Your ref: SSD 9063
File no: MC-18-00001

Re: SSD 9063 - Tallawong Station Precinct South (formerly known as Cudgegong Road Station South) - 69-79 Schofields Road, Rouse Hill

ATTACHMENT A

Flindersia australis

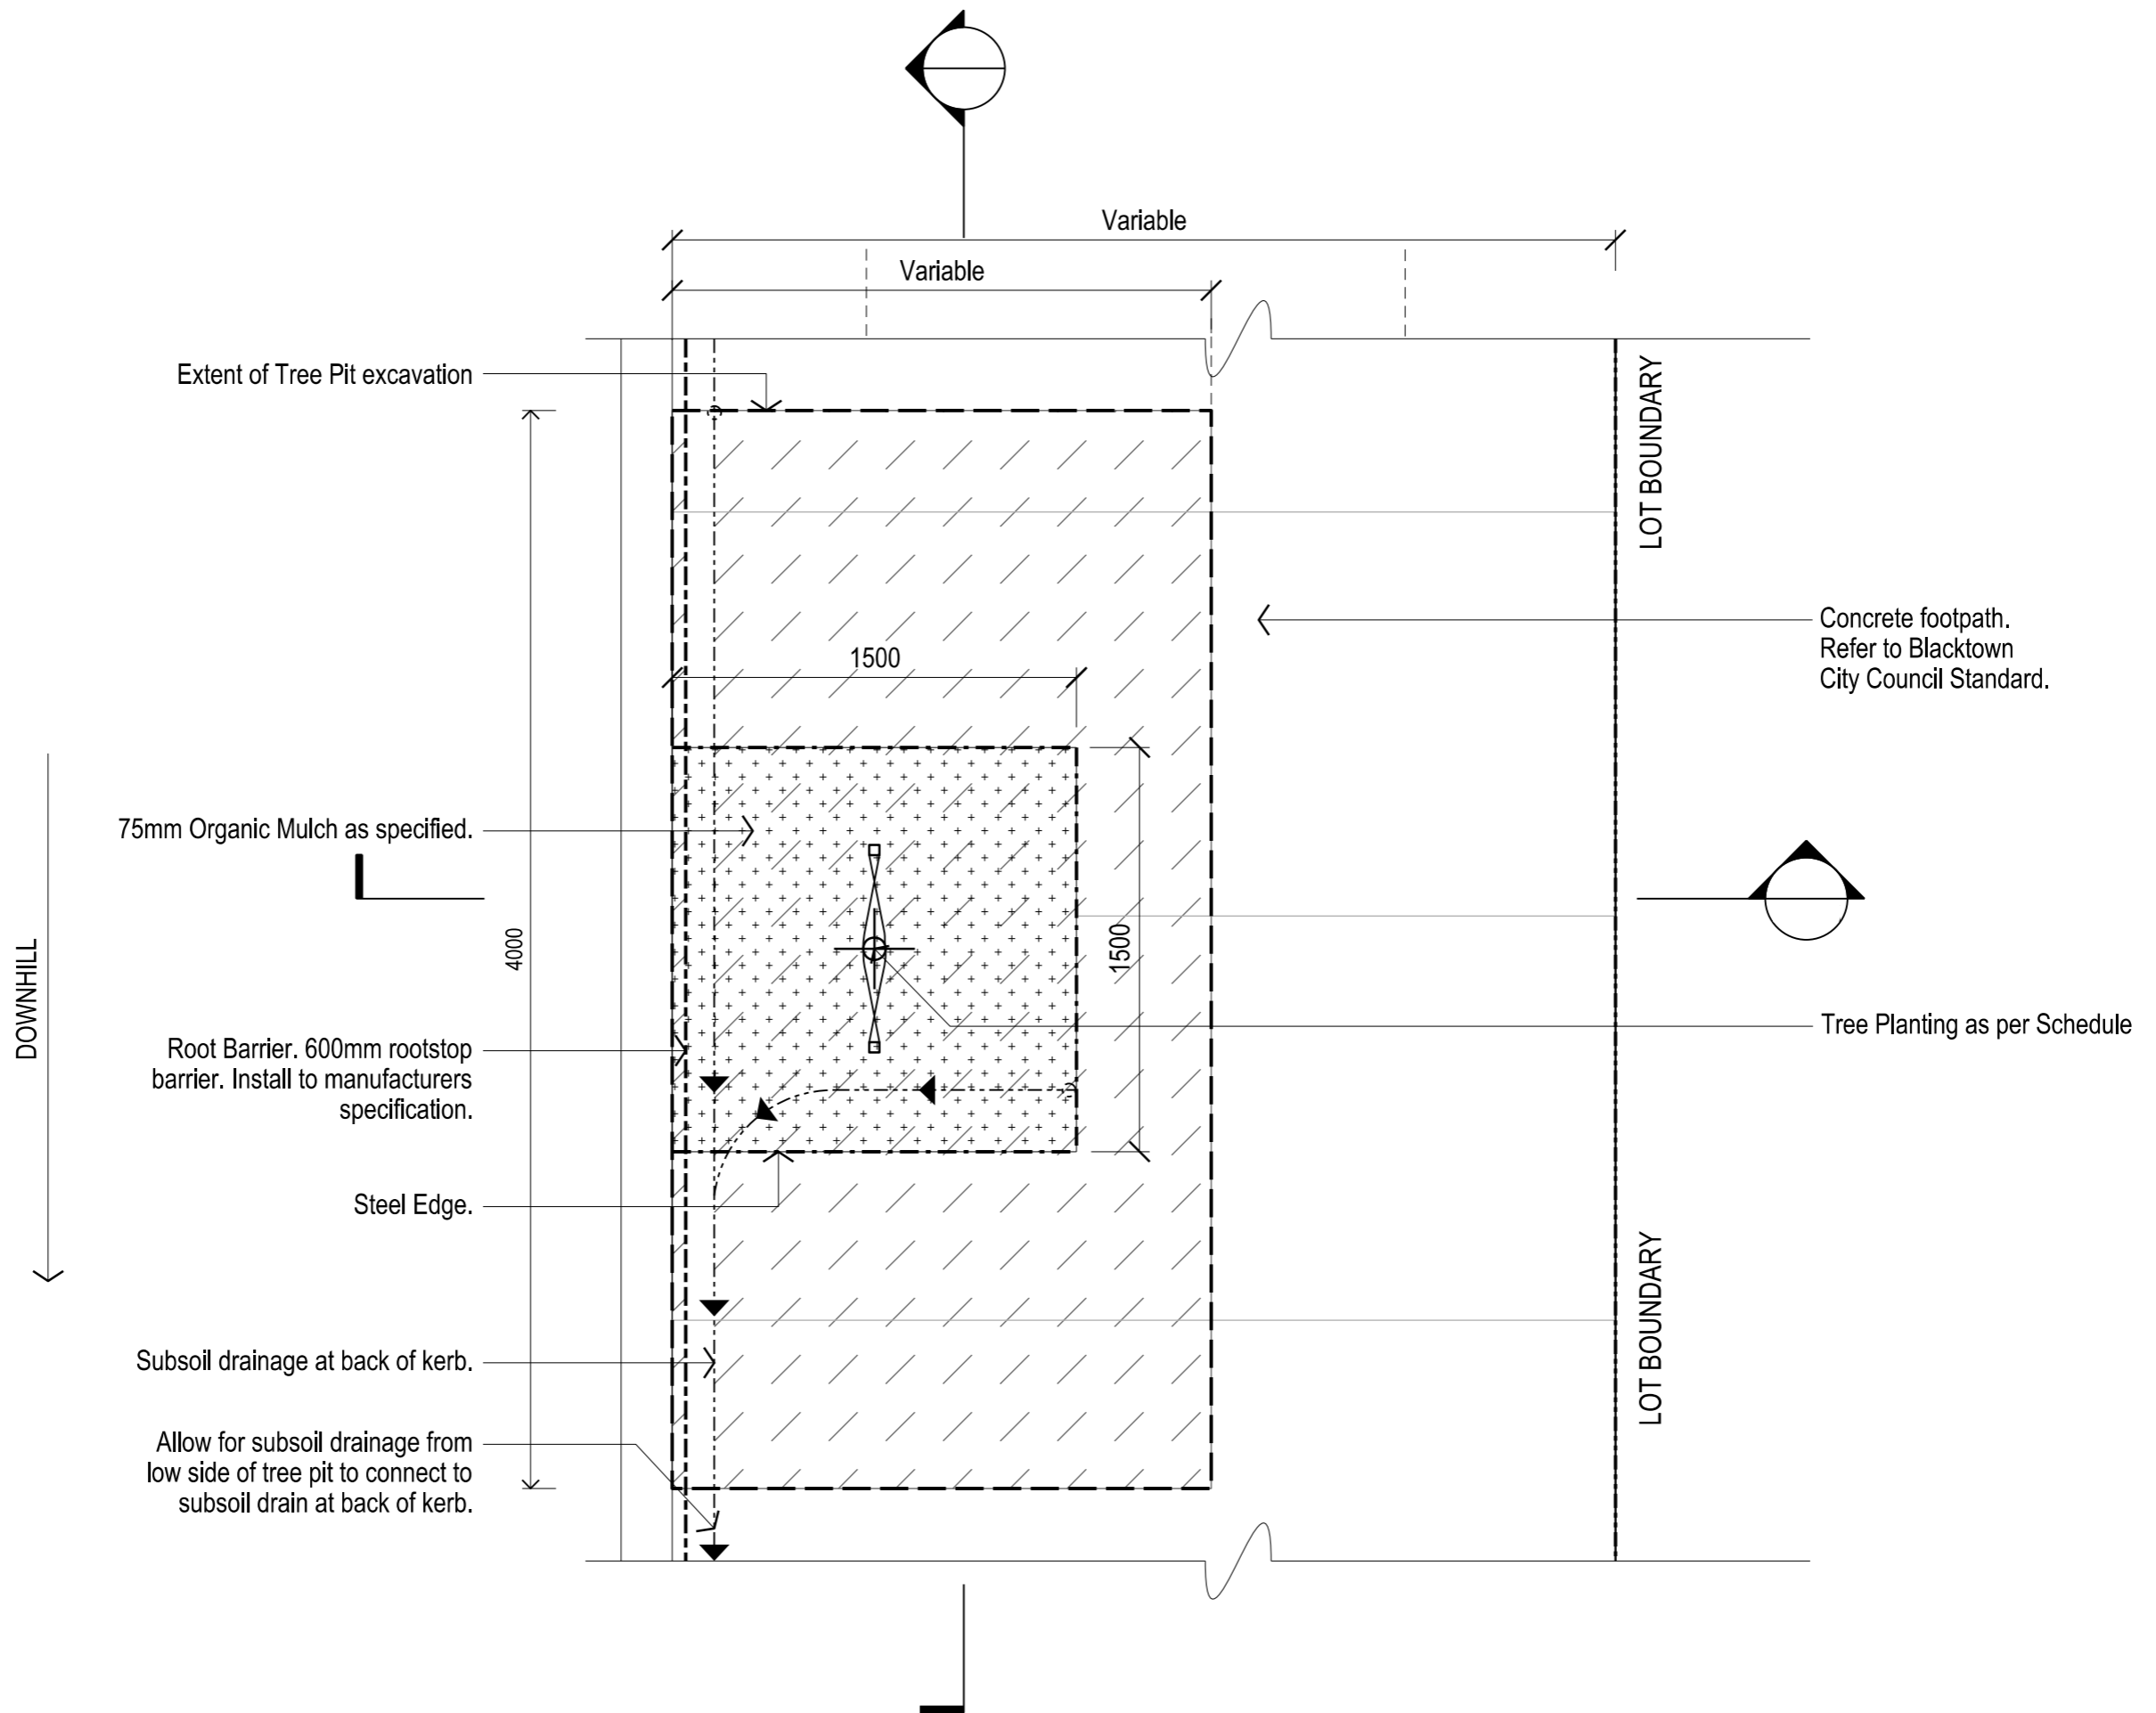
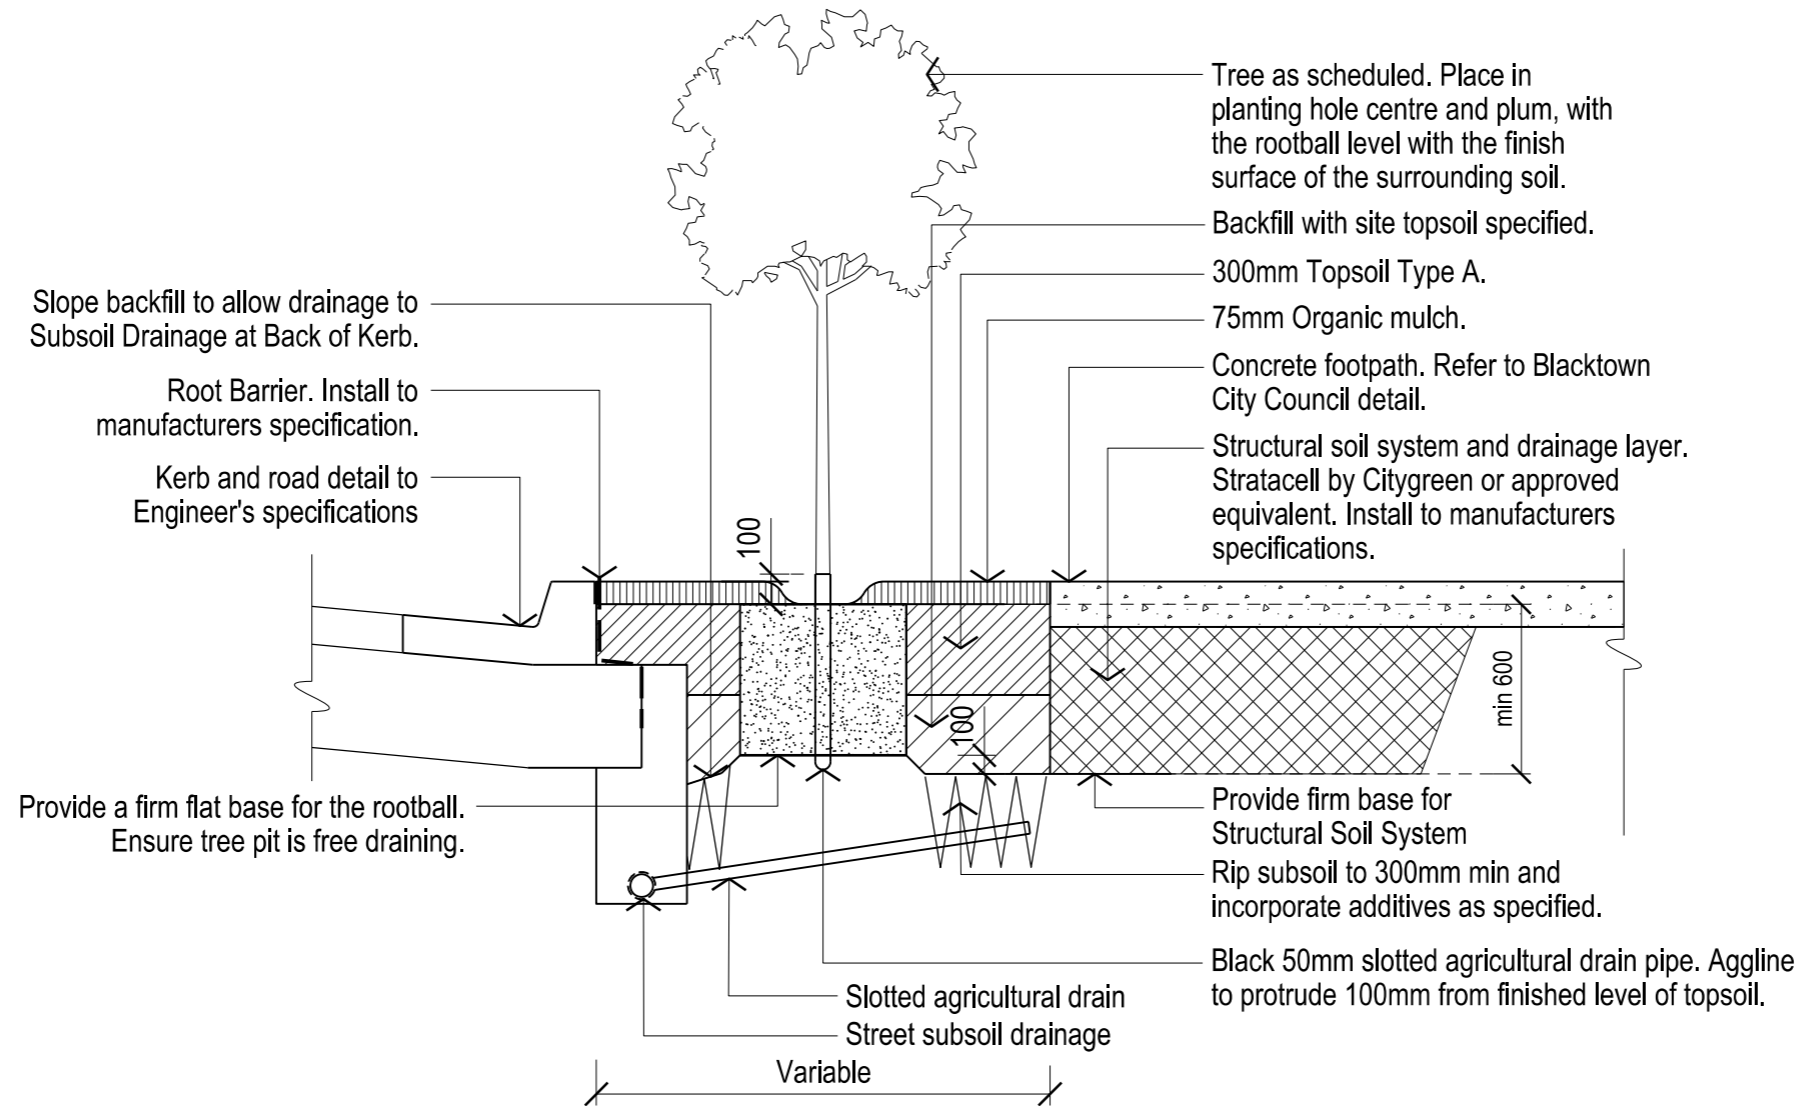
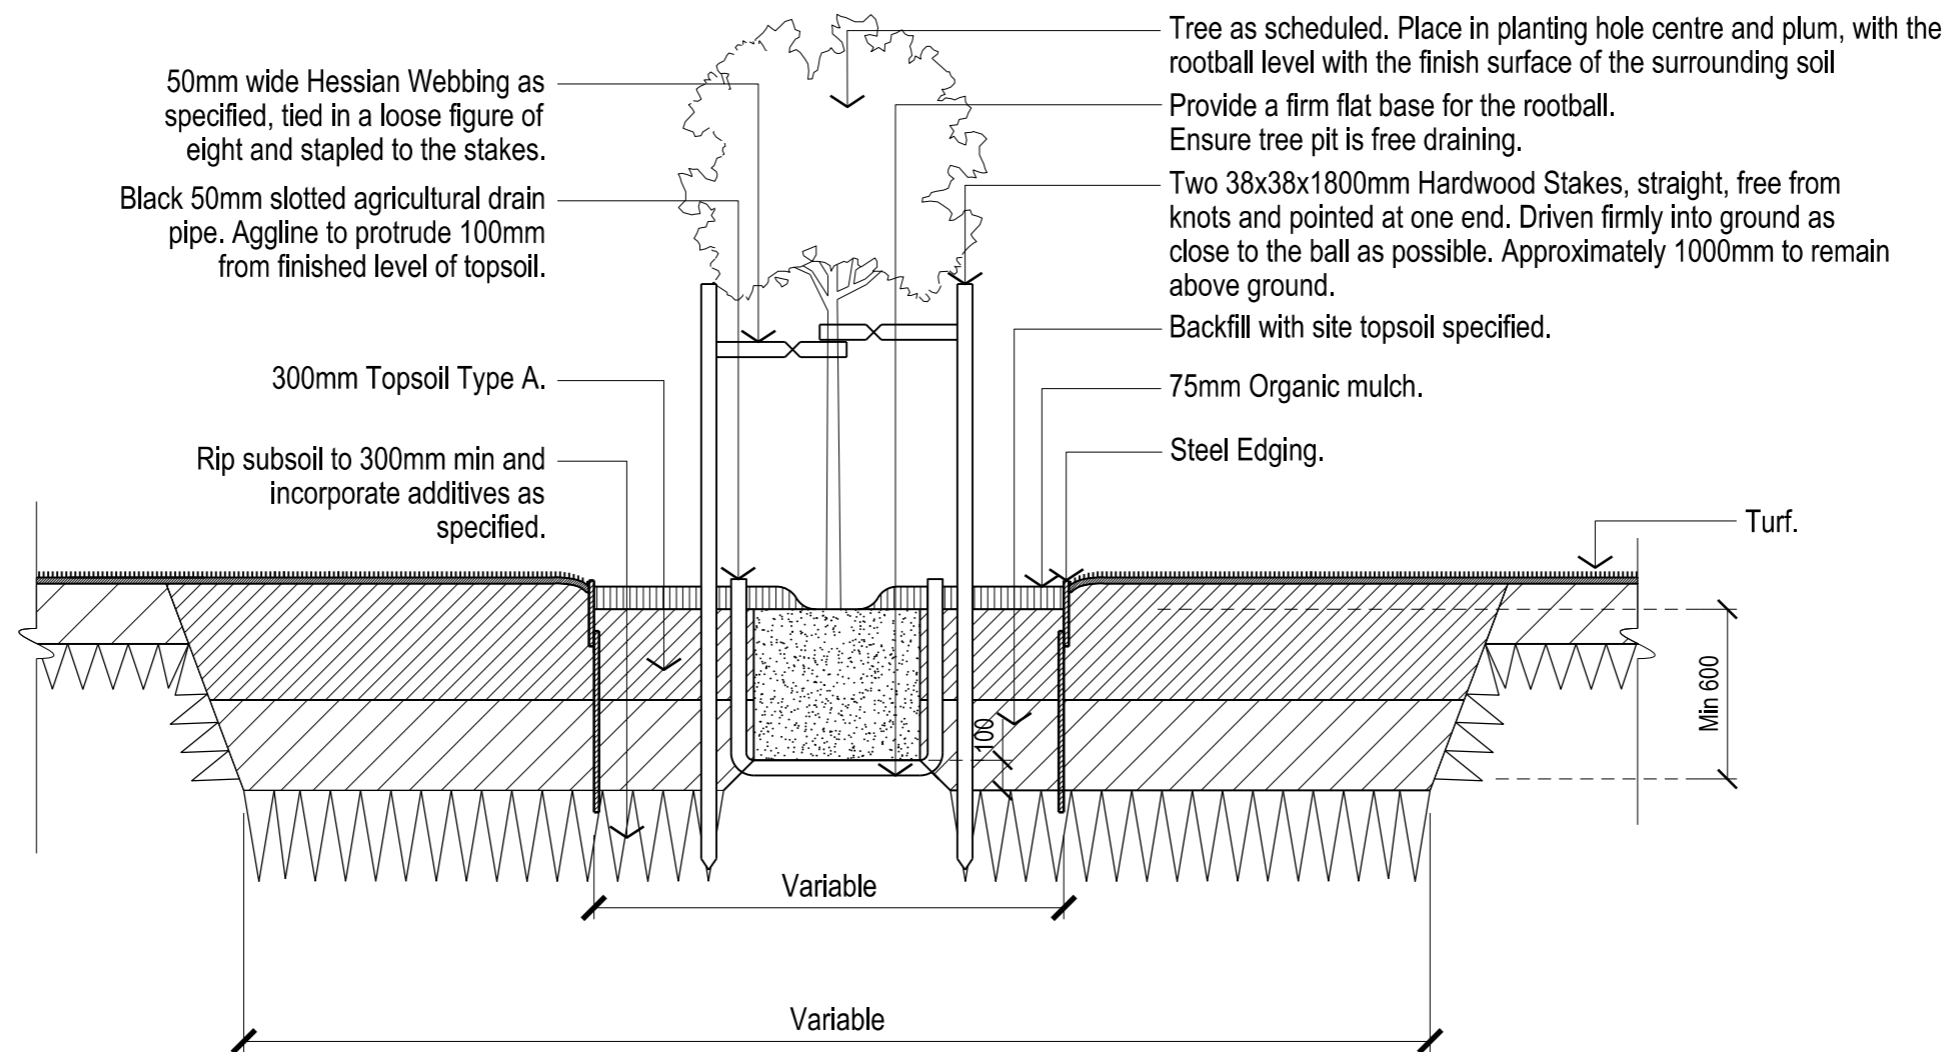
- h) No *Fraxinus griffithii* as street trees, alternatives *Fraxinus pennsylvanica* 'Urbanite' or 'Cimmaron.'
- i) Root barrier on kerb and path side of tree pits.
- j) Porous paving finish on street trees and plaza plantings no mulch in these areas.
- k) No steel edging on tree pits that adjoin turf areas.
- l) Page 5 of landscape plan has unacceptable species *Sapium*, *Jacarandas* and *Eucalyptus* species, street tree species on page 18 are acceptable but *Fraxinus oxycarpa* 'Raywoodii' can only be used in plaza plantings not as a street tree species.
